A46 Newark Bypass

Scheme Number: TR010065

Statement of Common Ground with Think Again A46 Winthorpe Action Group

February 2025

DRAWING NUMBER HE551478	ORIGINATOR SKAG	VOLUME HGN	PROJECT REF NO. HE551478
CONWI_CONW	DR	LE	00003
LOCATION	TYPE	ROLE	NUMBER
			C01

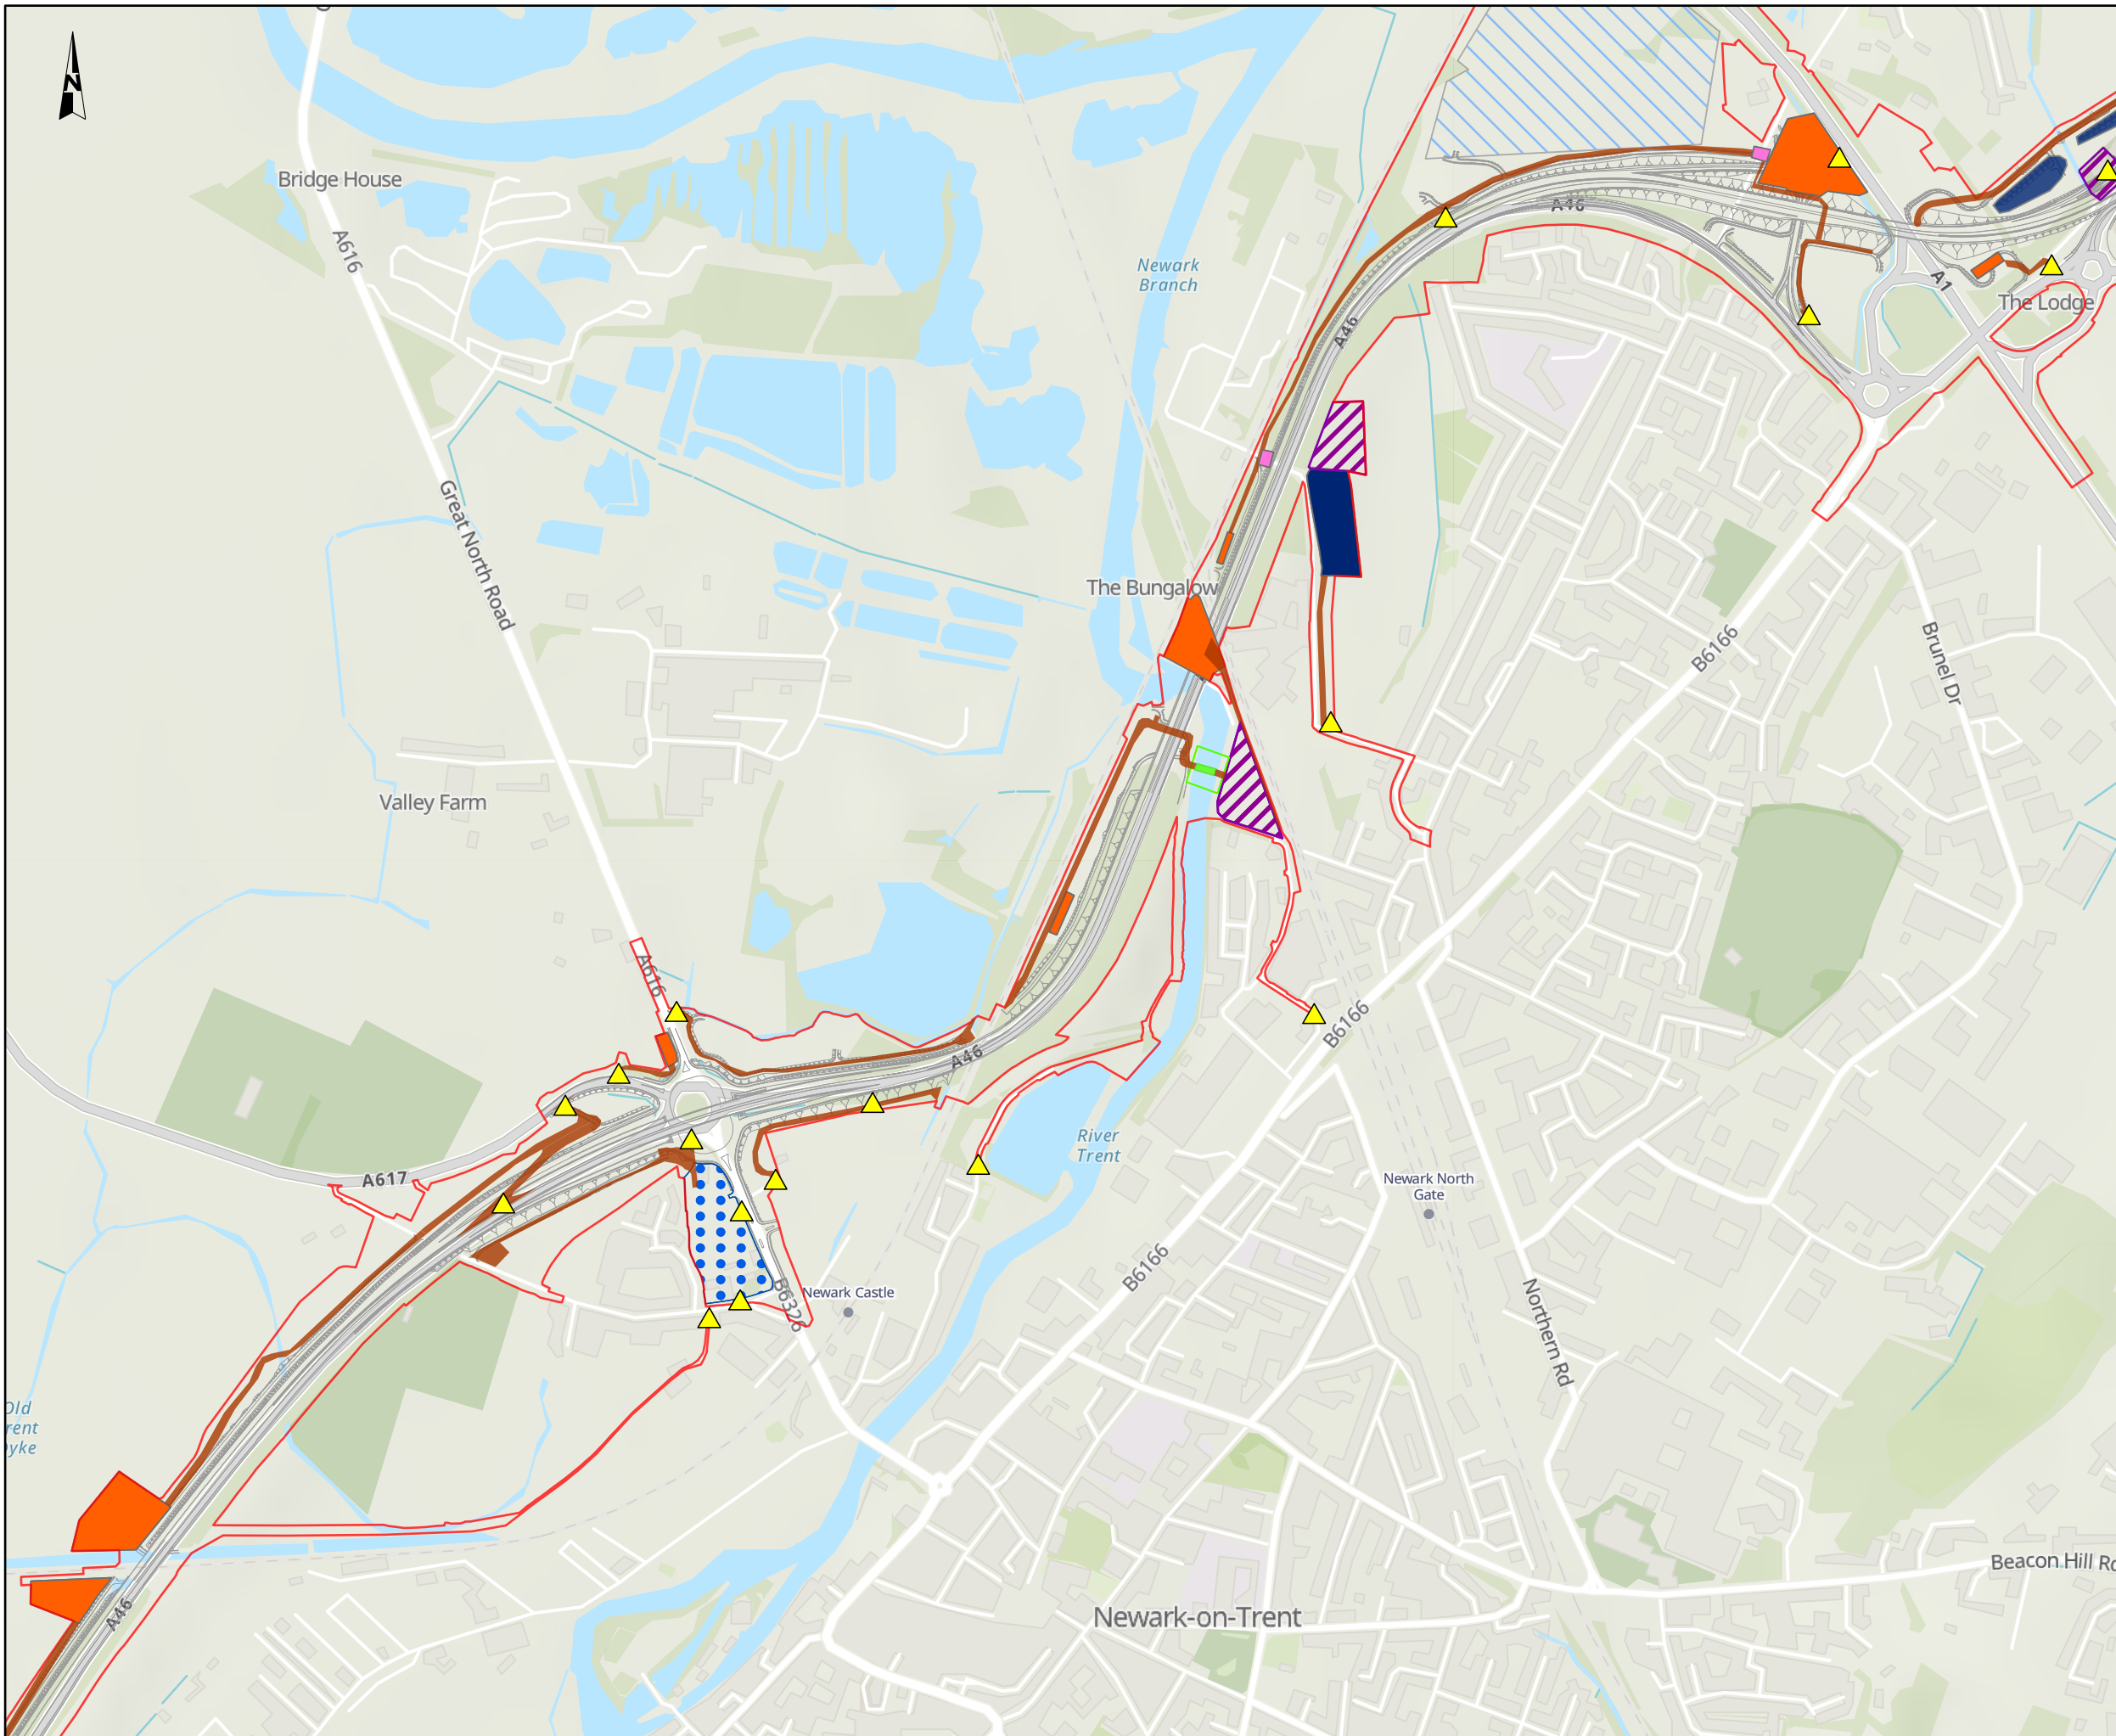
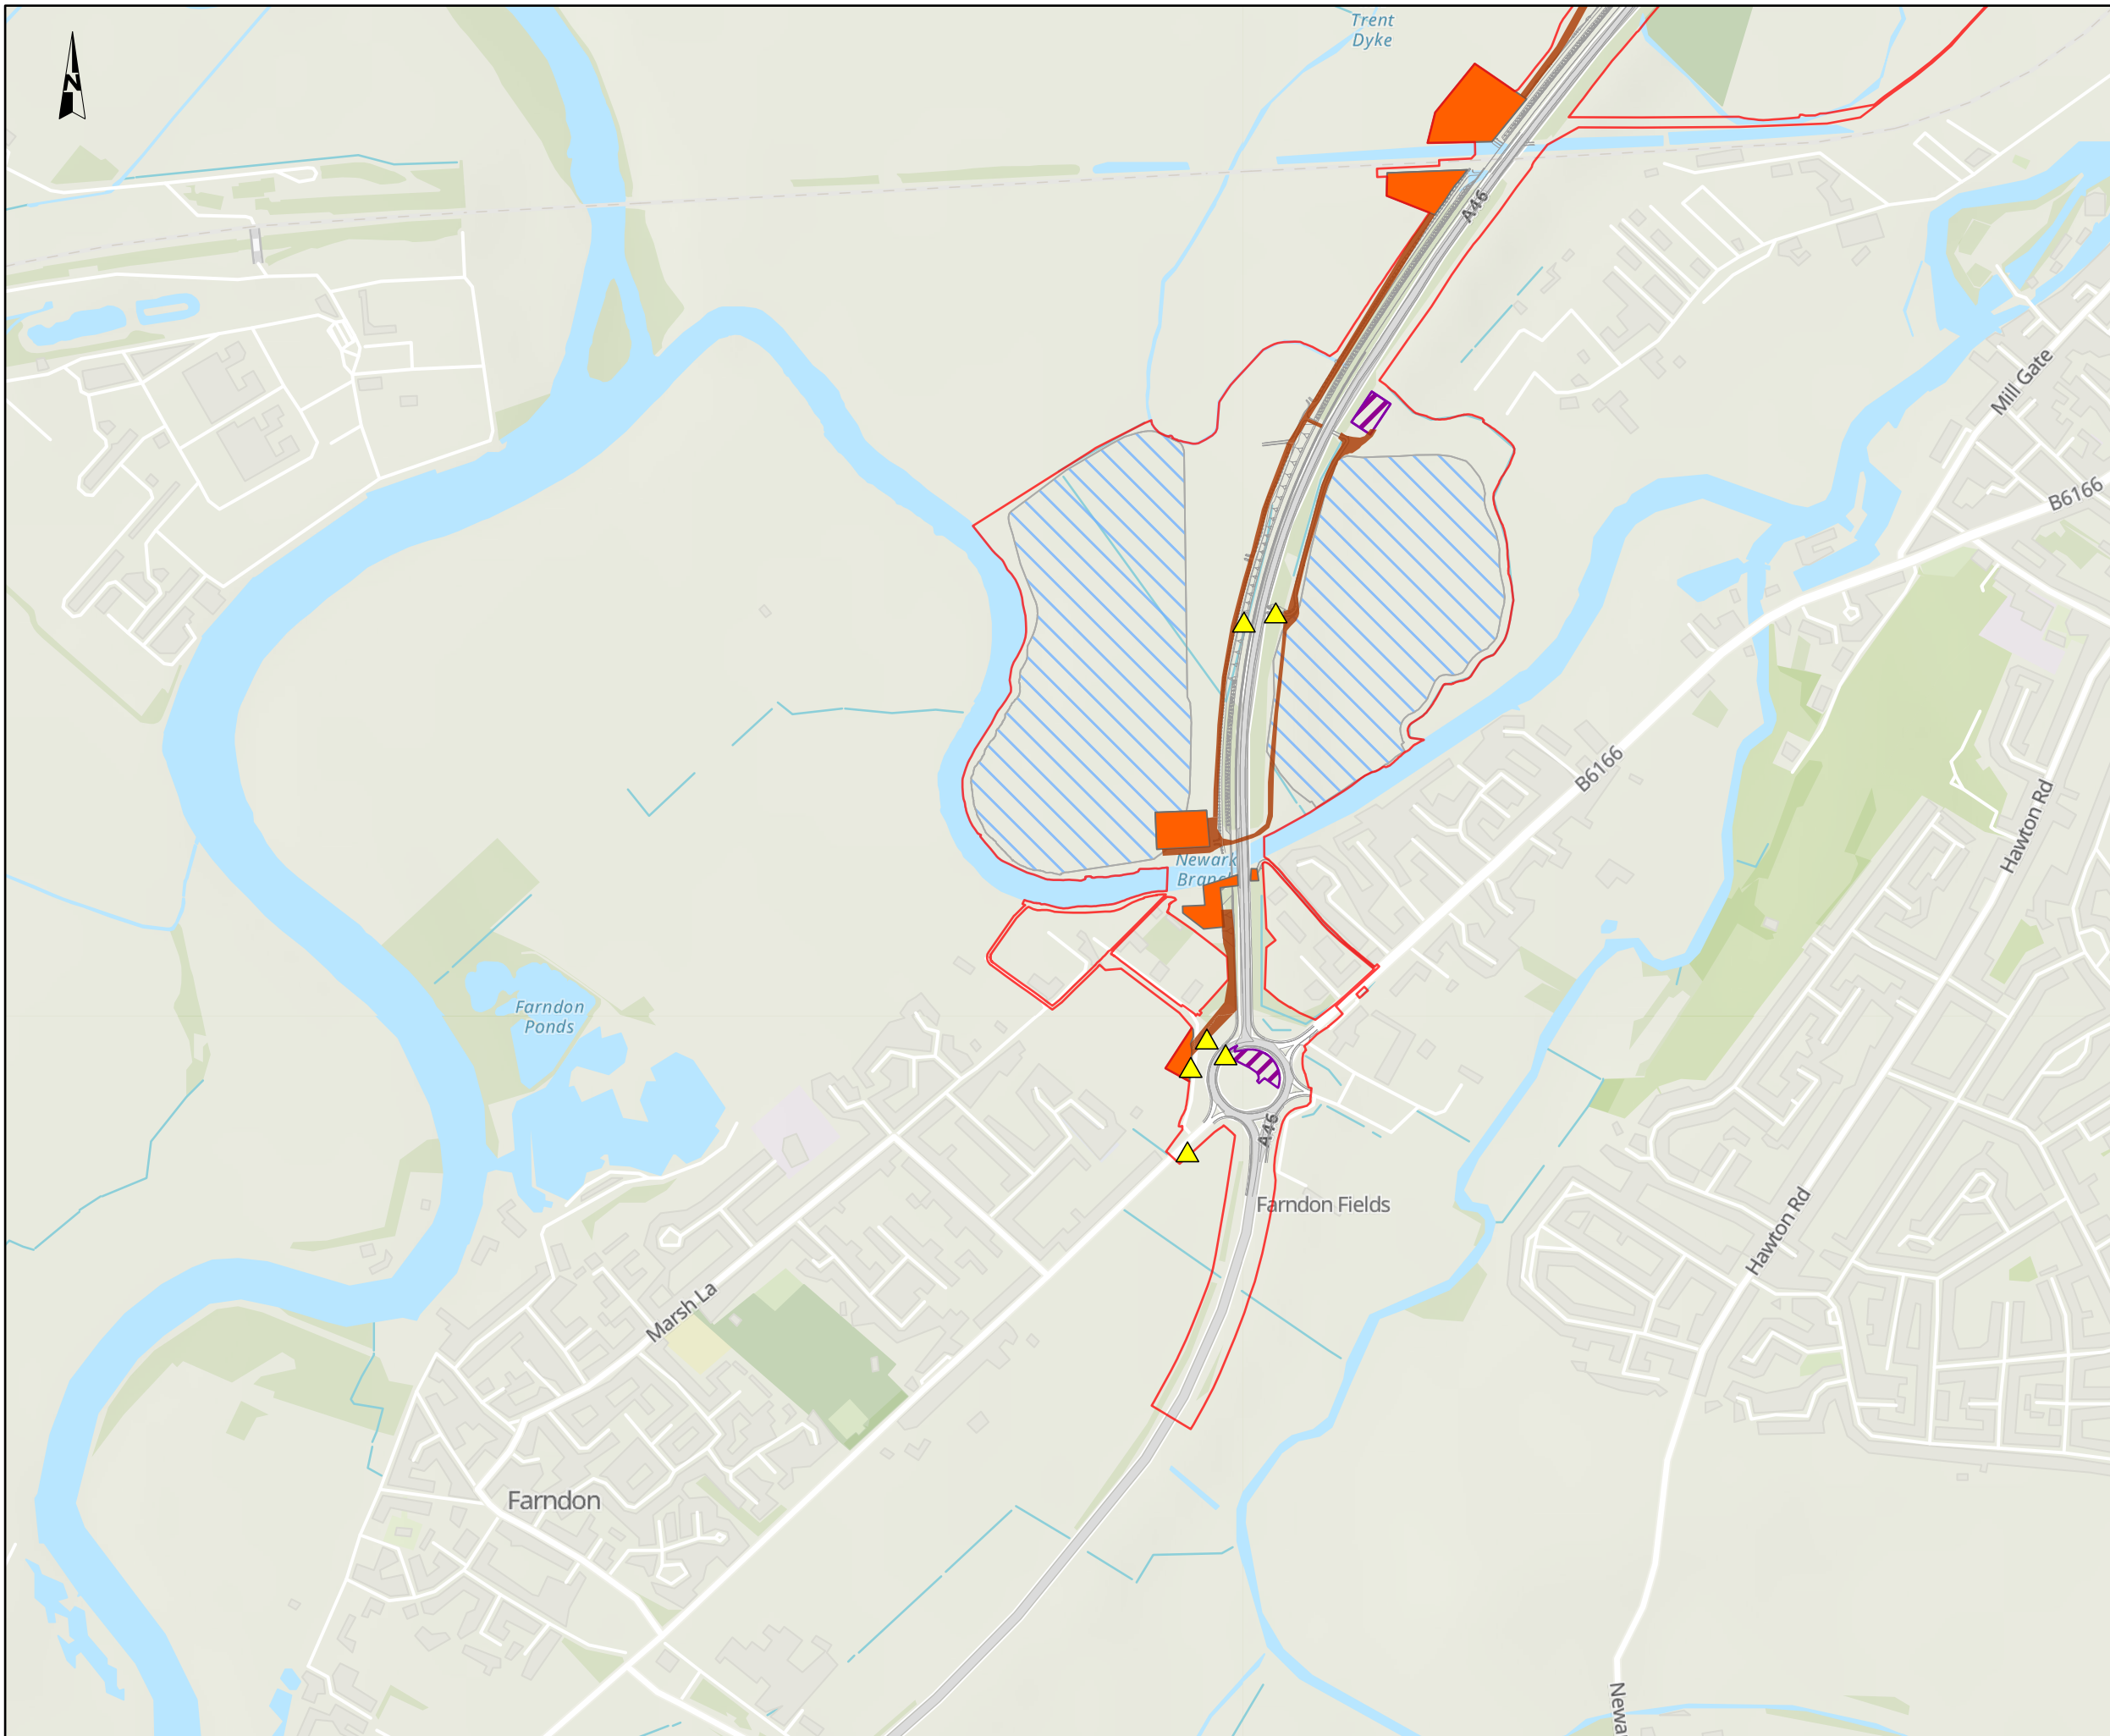
20.	Construction Compounds	Figure 2.4 Locations of Temporary Works Areas Required During Construction of the Environmental Statement Figures [AS-027] Table 2-6 in Chapter 2 The Scheme of the Environmental Statement [APP-046]	What construction compounds and works access facilities will be located in the Winthorpe area?	The location of the construction compounds and works access areas within the Winthorpe area are detailed on Figure 2.4 Locations of Temporary Works Areas Required During Construction of the Environmental Statement Figures [AS-027] and in Table 2-6 in Chapter 2 The Scheme of the Environmental Statement [APP-046].	Agreed	24/09/2024
